Formal Objection to planning application 20/00934/FUL for 8 houses on land to the rear of The George Inn, Sandford Road, Littlemore

Having viewed the application documents and plans for the above development, the following are my objections to the scheme.

Figure 3: B1, near the east boundary of the Site

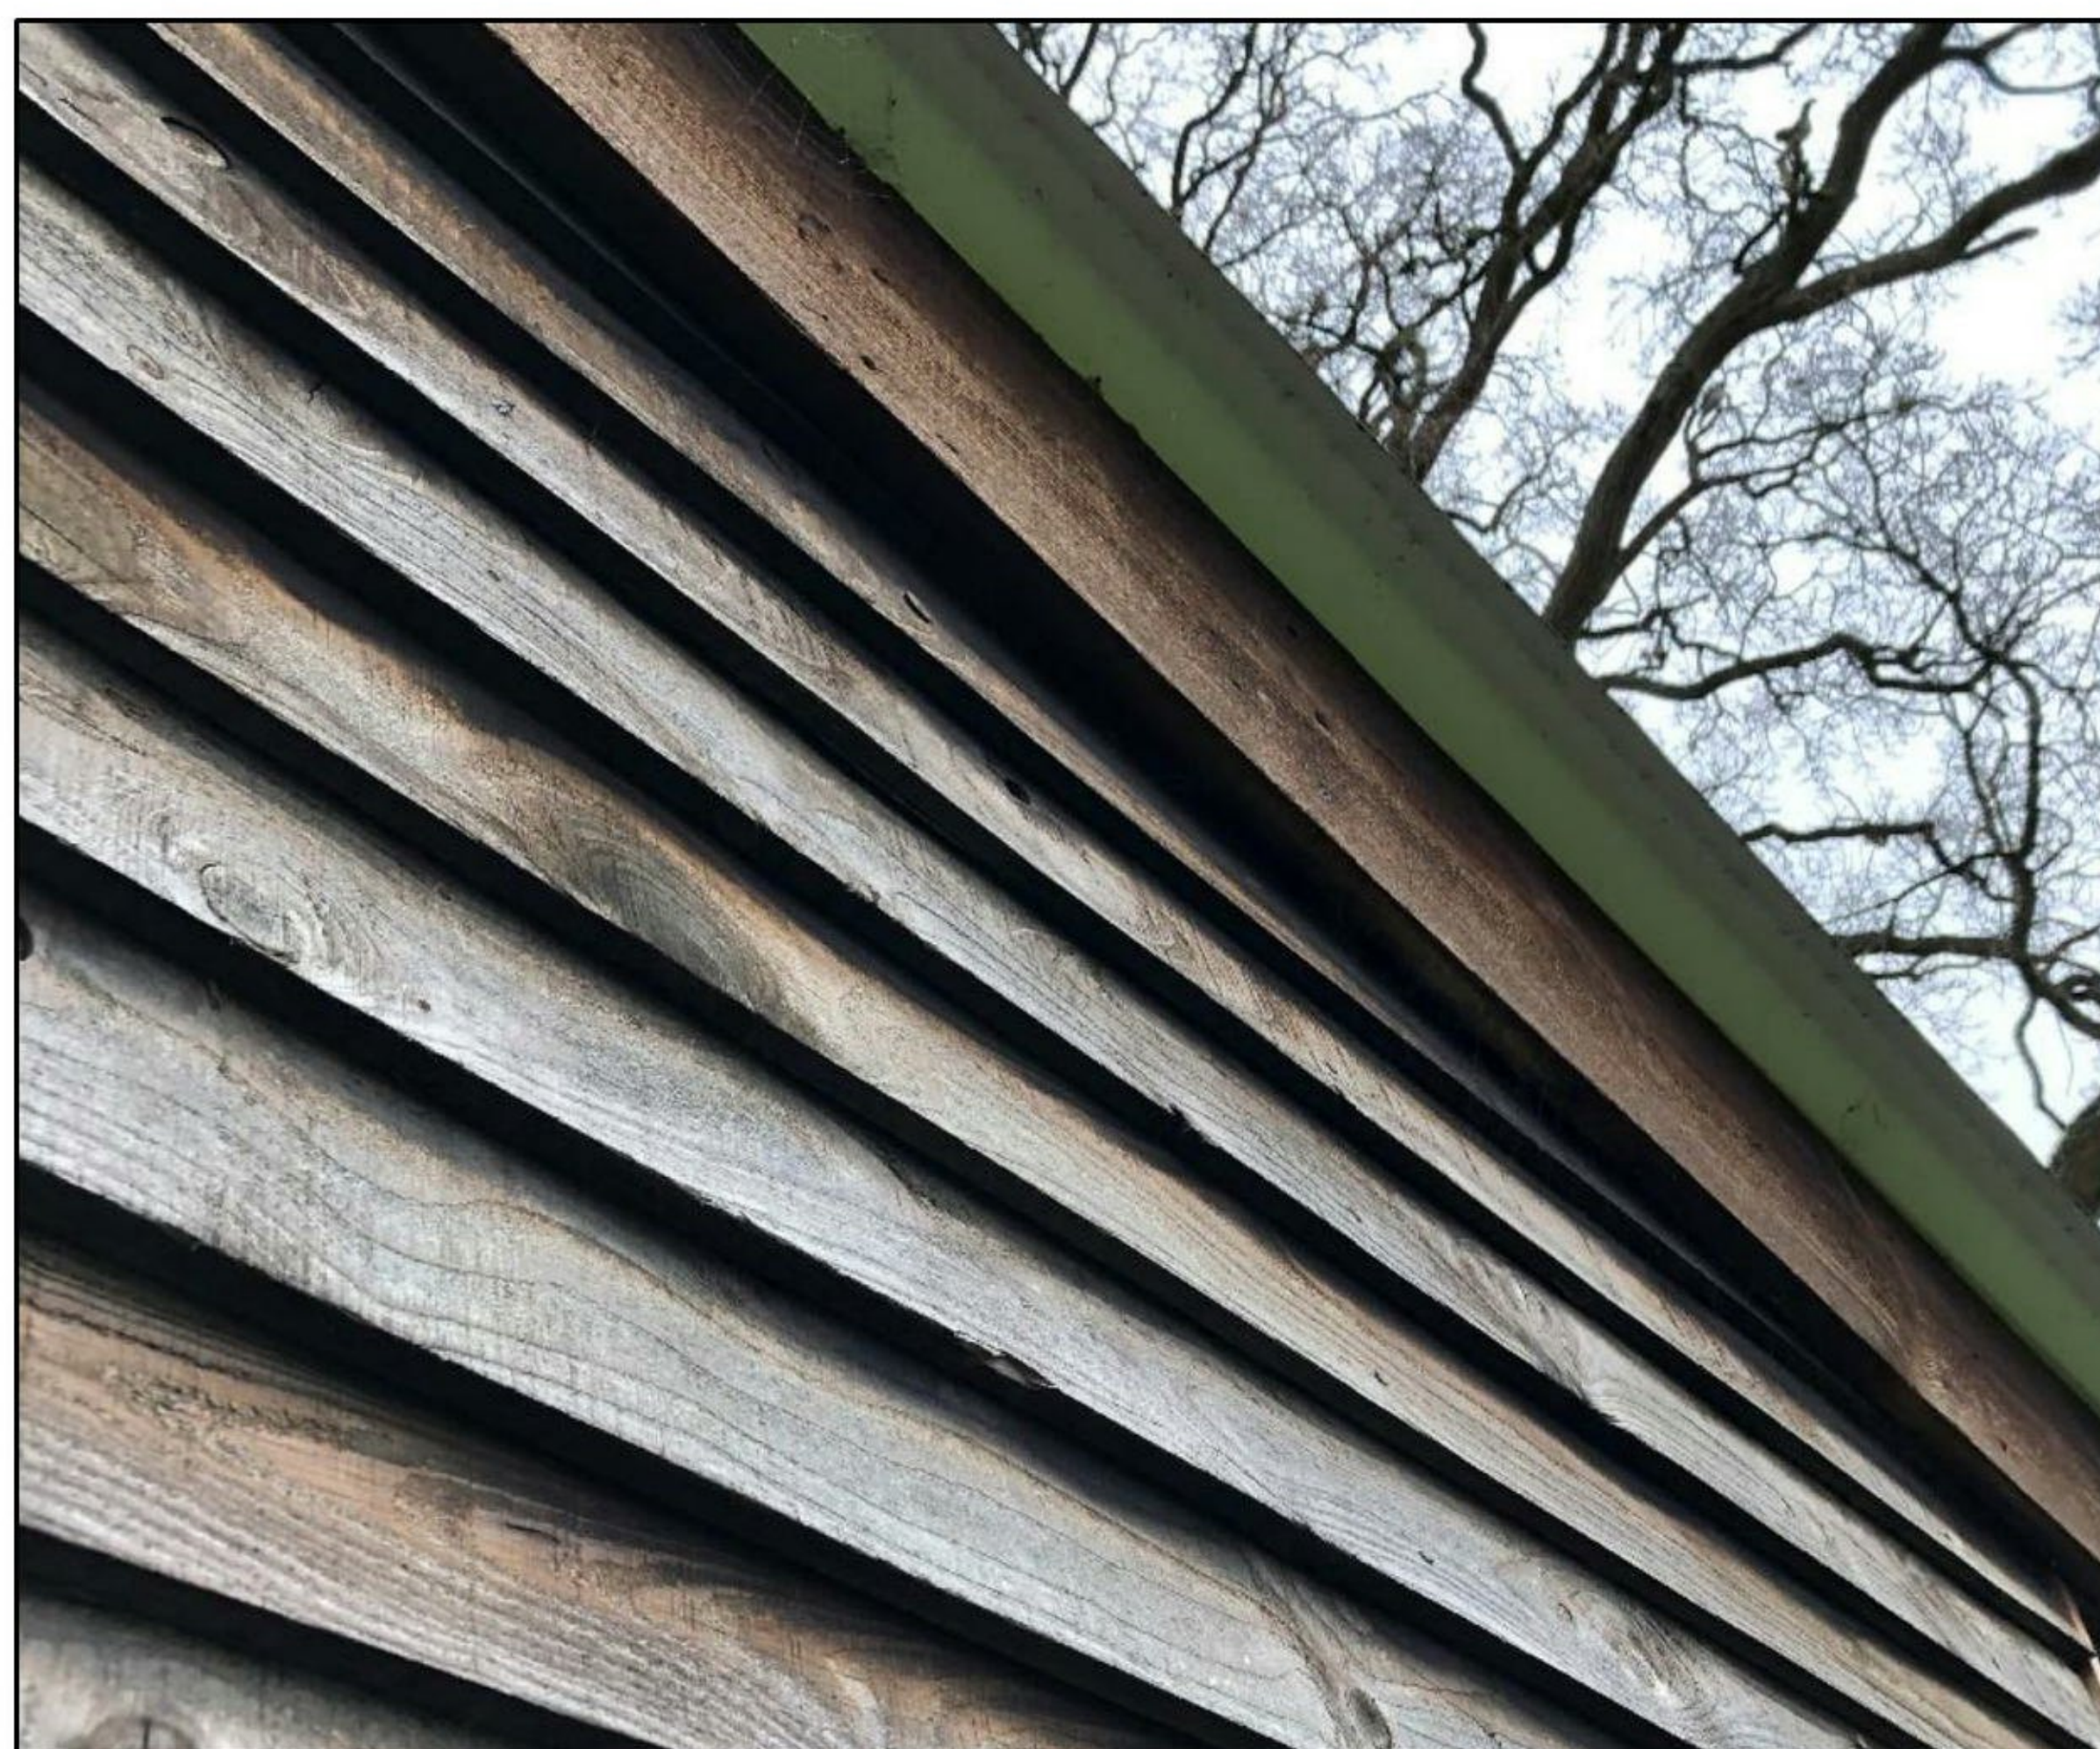
No 1 Sandford Road - Although this property is aligned side on to the proposed development the upper floor windows on the front elevation have a clear line of site into the proposed development.

The following photographs are taken from the Ecology report, which show the site, but helpfully also show the windows of some of the houses adjacent to the site which clearly evident in the photographs.

Figure 3: B1, near the east boundary of the Site

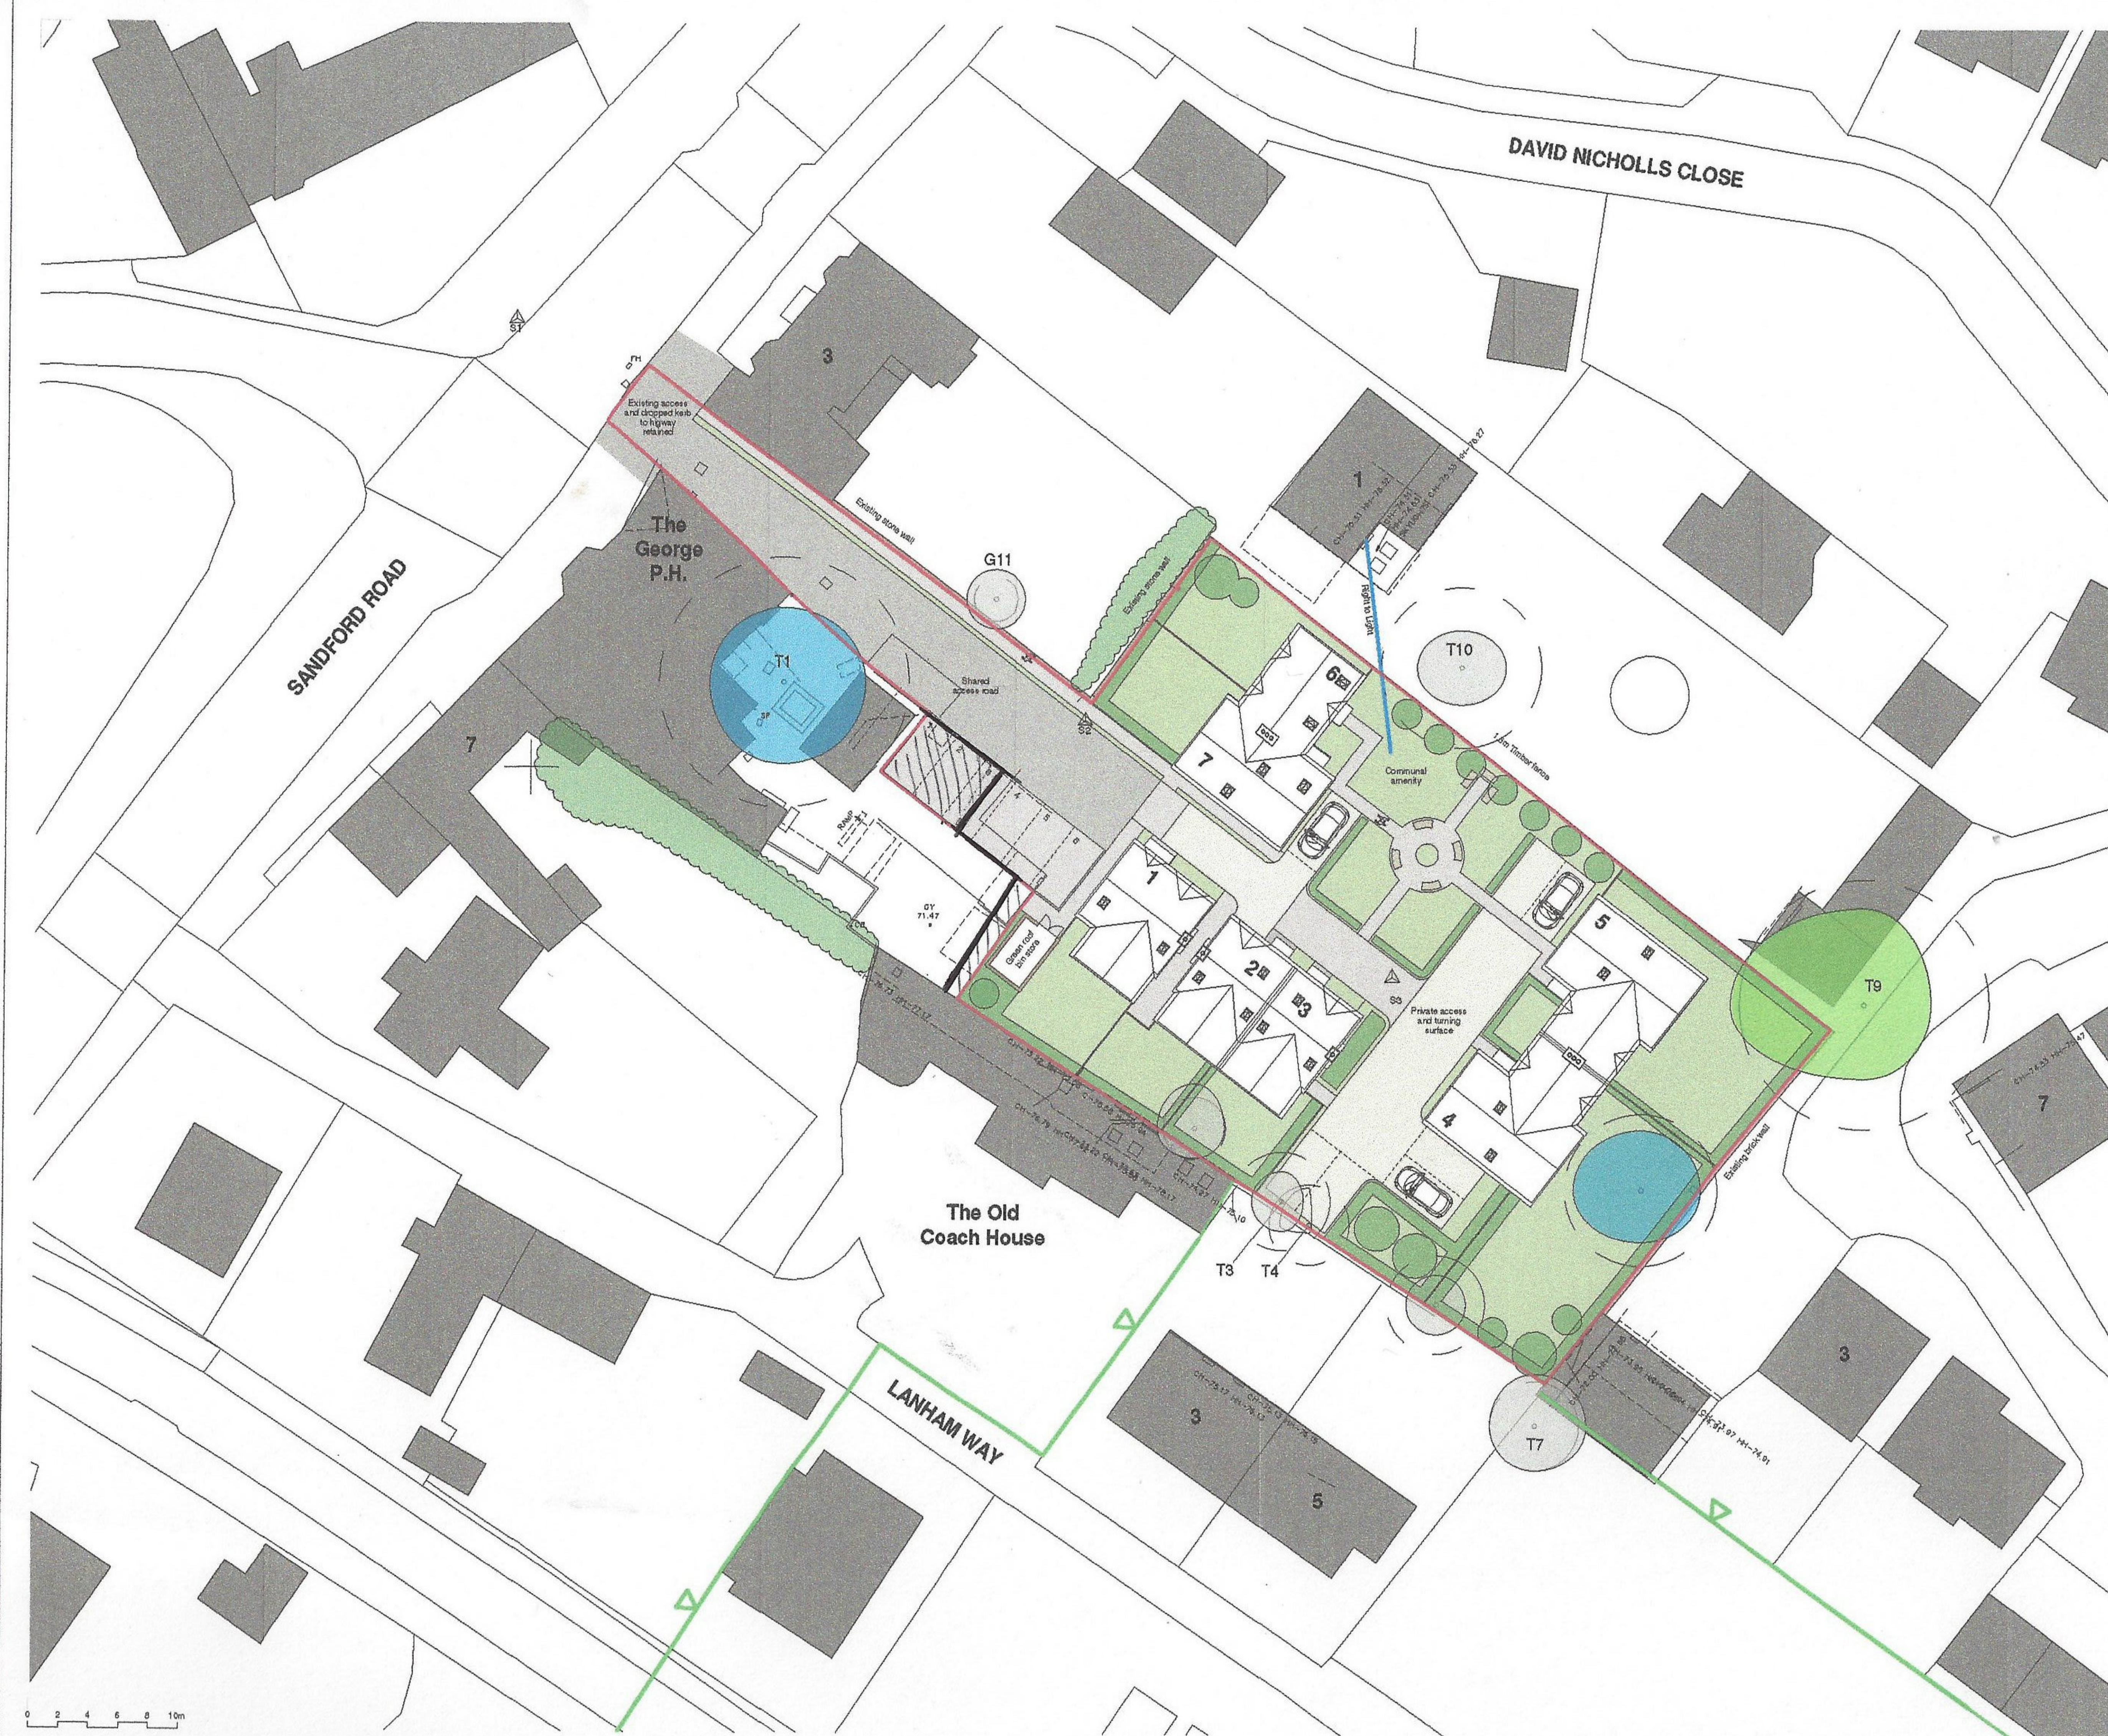
Furthermore, the application documents (Forms, D&A and Transport Statement) indicate that 7 spaces would be created for use by the retained public house, including the demolition of a wooden structure behind the pub to make way for the parking spaces. However, there is a significant issue with the way the plans have been drawn. The application boundary shows 5 ½ spaces to fall outside of the application boundary and therefore cannot be delivered by this application. There are no parking spaces in this location apart from some parallel spaces running in line with the access road. Which means the proposed parking spaces would have to be physically constructed and therefore should fall inside the application boundary. It is understood that the applicant does not own or control the land outside the redline which calls into question the ability of the applicant to construct these parking spaces, regardless of whether they are within the red line or not and furthermore, whether they have permission to demolish the wooden structure as this is part of the public house.

extract from Proposed site layout plan

As shown above the red line has clearly been drawn through parking space number 6 and it excludes 5 parking spaces. Ultimately this means the application can only provide 1 ½ parking spaces for the public house, as the remaining 5 ½ spaces are not included within the application boundary. This is not acceptable and 1 ½ spaces does not meet that Councils required parking standard. It would severely affect the ability of the public house to trade effectively.

**Land to rear of George Pub  
Littlemore**

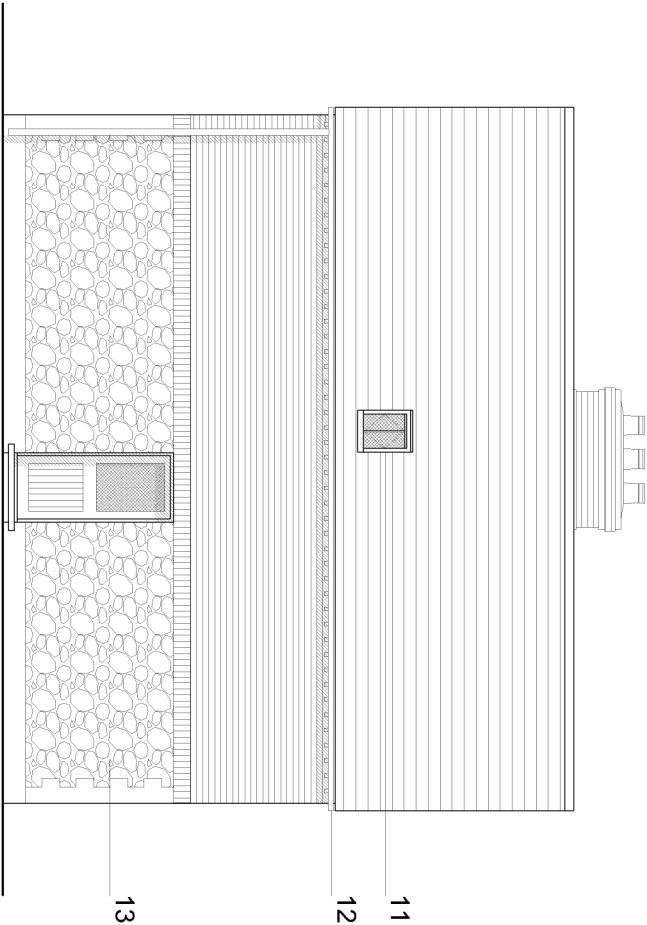
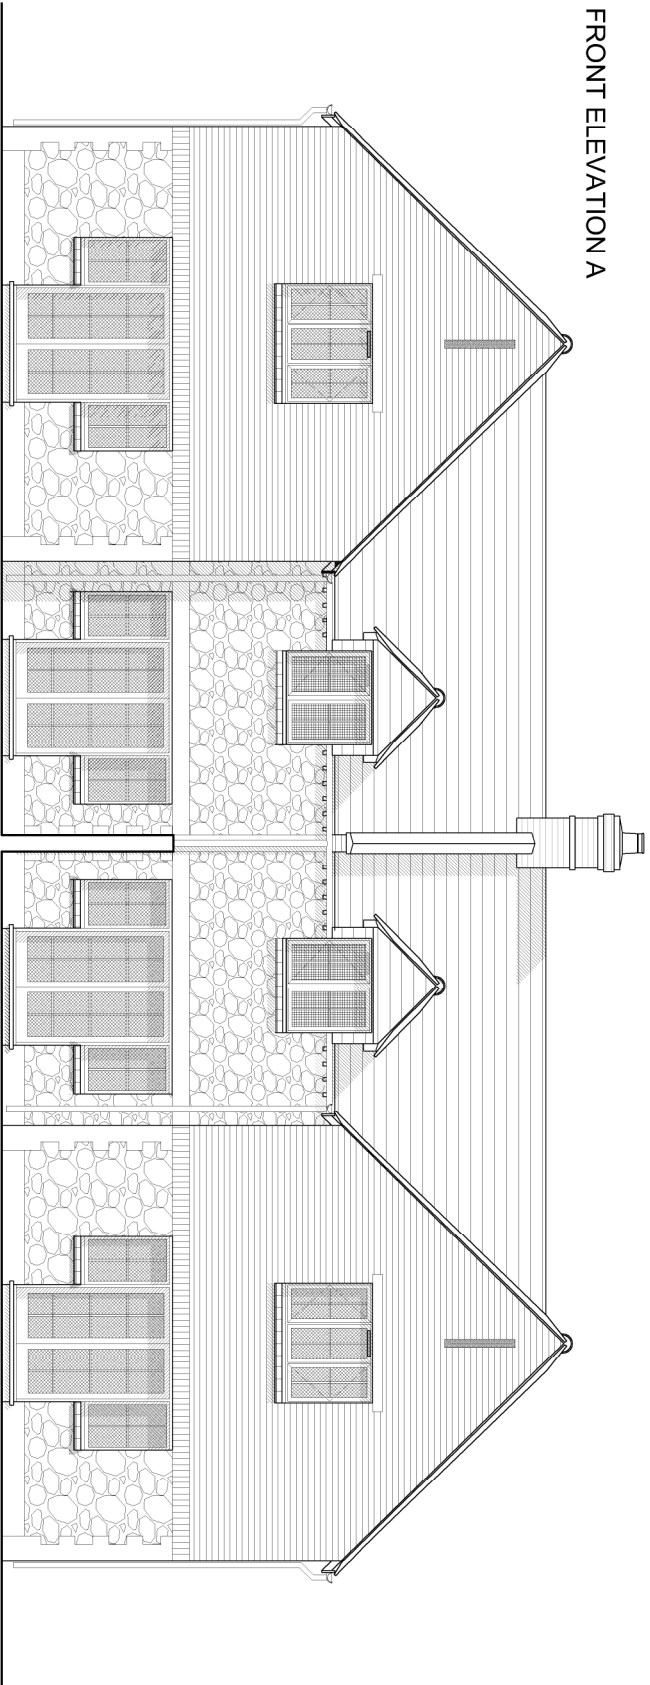
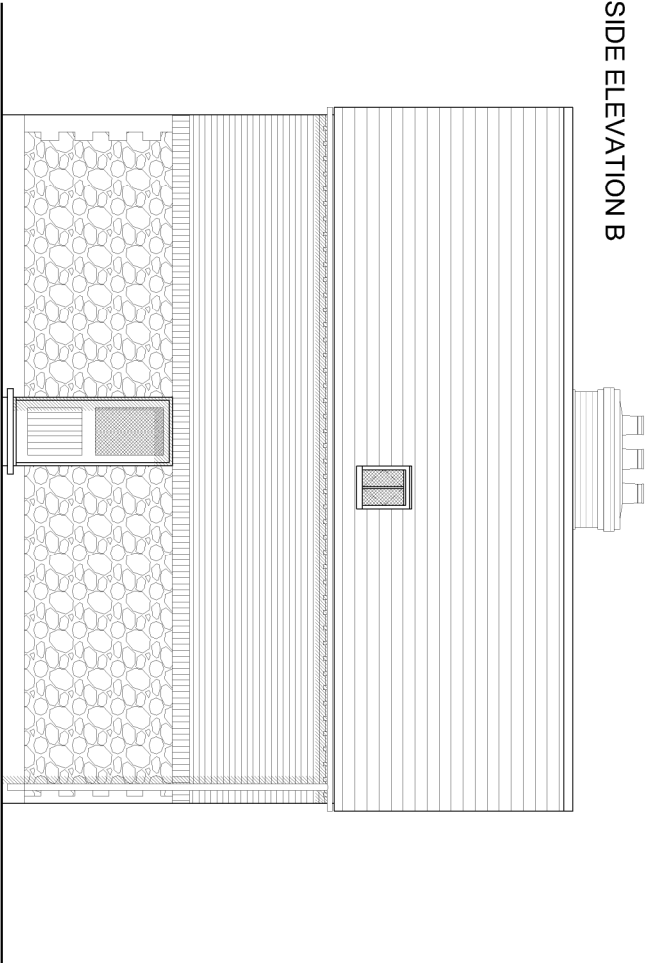
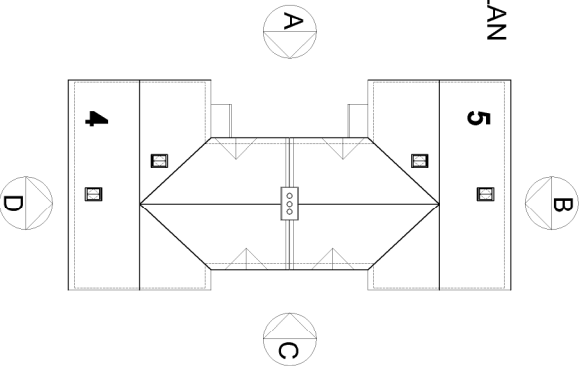
In terms of design, the terrace of plots 5 to 8 (albeit Plot 5 is a detached unit) has the appearance of an old factory building with its multiple gabled pitched roofs and then a large chimney on plot 5. The addition of Zinc clad sections between the roofs add to the confusing design concept. The other properties have been treated in a similar manner to try and create a harmonious design throughout the development. However, the result is a design that is alien to its surroundings and whether it is scarcely visible from Sandford Road or not, it is argued this proposal would have a harmful and negative impact on the character of the Conservation Area. NPPF makes it very clear that poor design should be rejected and only high quality designed schemes should be viewed positively. It is argued that the design of this application fails to respect its location and the over cramped nature of the layout would be harmful and be contrary to the guidance in NPPF and Policy HE7.
